Northconnex Project Application Number – SSI 13_6136

Thank you for the opportunity to comment on the Environmental Impact Statement for this project. I have become personally acquainted with its details through family members that live in Wahroonga close to the proposed Northern Ventilation Facility. I am a qualified and practicing town planner, so also have a degree of professional interest in this project.

M1-M2-5000-DR-UD-0550
NORTHERN VENTILATION FACILITY - CROSS SECTIONS

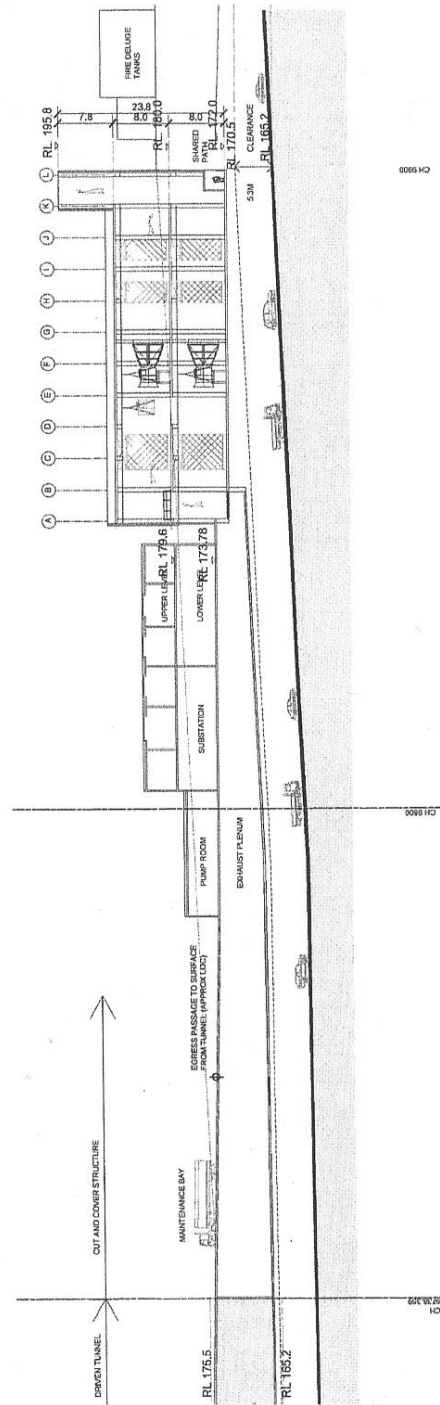
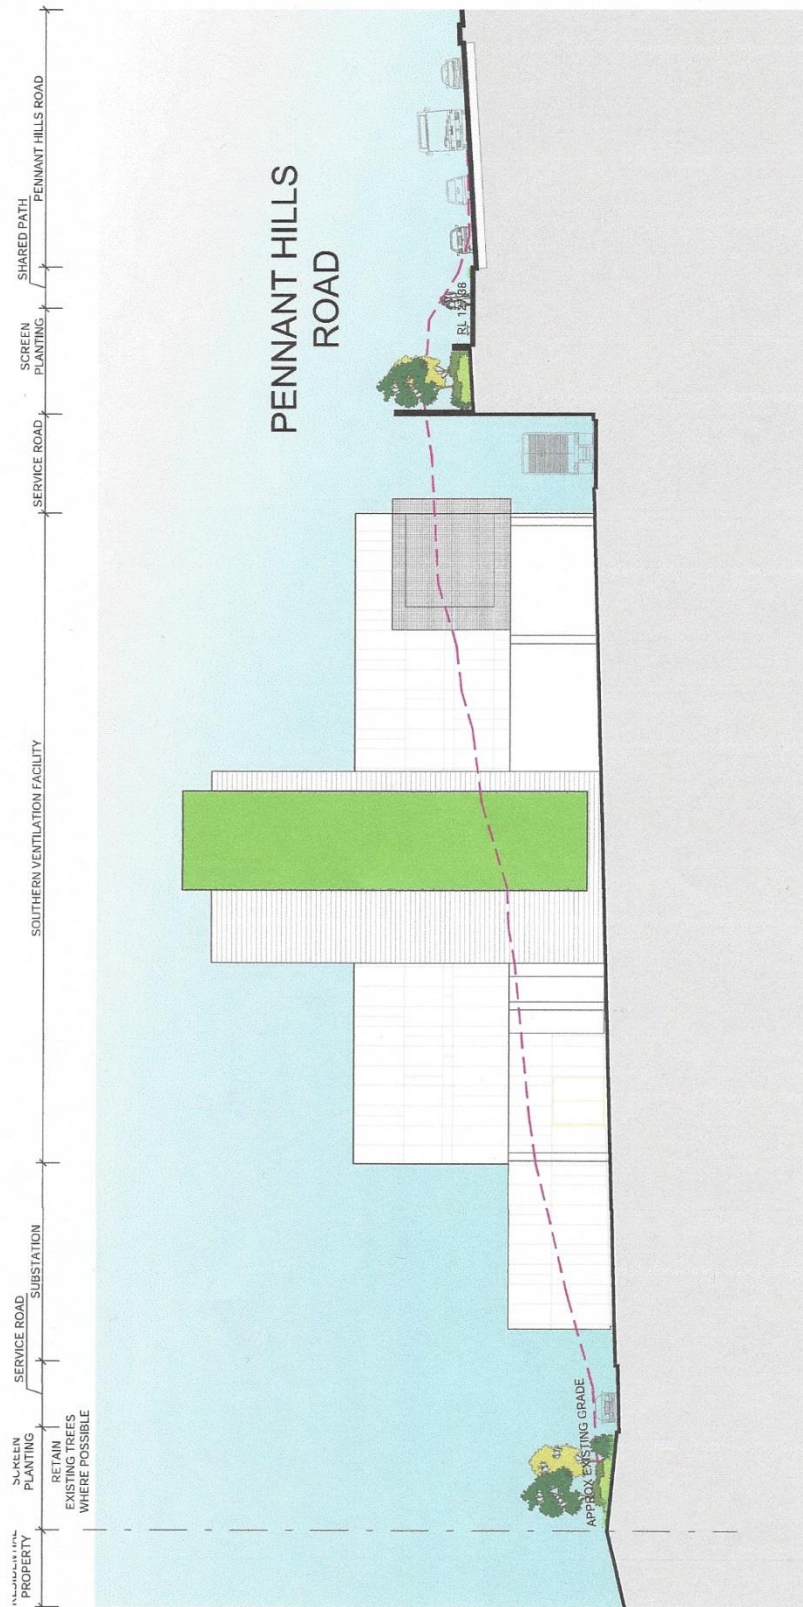
There is the possibility of more intensive landscaping at the northern end of the facility which will provide screening. However on the Woonona Avenue North frontage the main screening will come from street trees in front of the noise barrier wall. This landscaping is provided on the street reservation (owned by Hornsby Council) rather than on the site of the facility, and the EIS is silent on whether agreement has been reached for this to happen and who will have maintenance/planting responsibilities.

In terms of screening the facility the proposed trees in this area appear in terms of height to be adequate, however this is provided they reach their full potential, which is not always predictable. The depth of the landscaping with only one layer of trees would appear to only provide partial screening. The trees also will take 10-20 years to reach maturity, so for a considerable period of time the facility will be effectively unscreened in any sense at all on Woonona Avenue North. This is evident in the artist's impressions which show the facility unscreened by the immature tree plantings. My conclusion is that landscaping cannot be guaranteed to safeguard the impact of this facility on the WNHCA.

- Minimising the bulk and height of the facility as much as possible.
- Using materials and a building design that is in keeping with the conservation area.
- Relocating the deluge tanks so both are as close to the Motorway as possible, enabling again a greater area of perimeter landscaping to be provided.
